From: Nicola Moore
Sent: 07 December 2021 16:40
To: Jon Boyazis
Subject: RE: Request for further information LU/371/21/PL

With reference to your email below, when we receive plans we check the measurement of the scale bar to ensure it is correct. In this case, when I measure the Location Plan as 1:1250, the scale bar measures approx. 46m and not 50m, and the Block plan measures 46m at 1:500.

site & block plan tp782/09

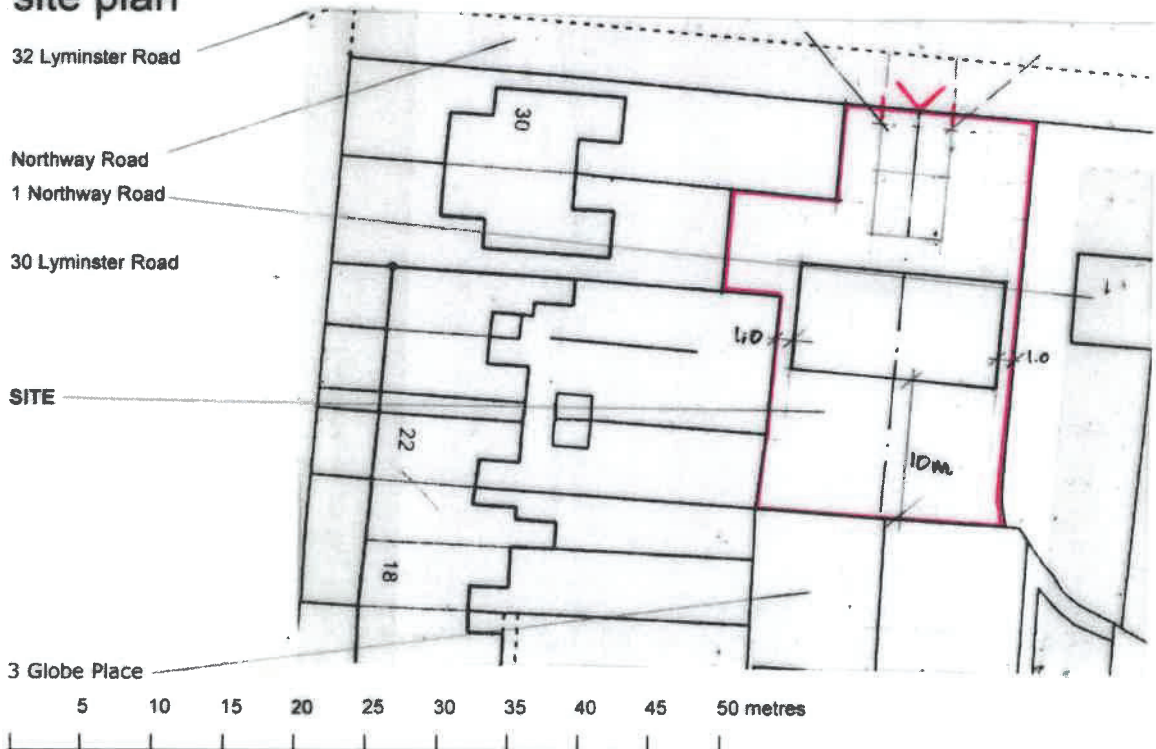
Please re-submit both plans. You will need to ensure they are scanned at actual size, or, if it is easier, the original colour copies can be sent to me at the address below.
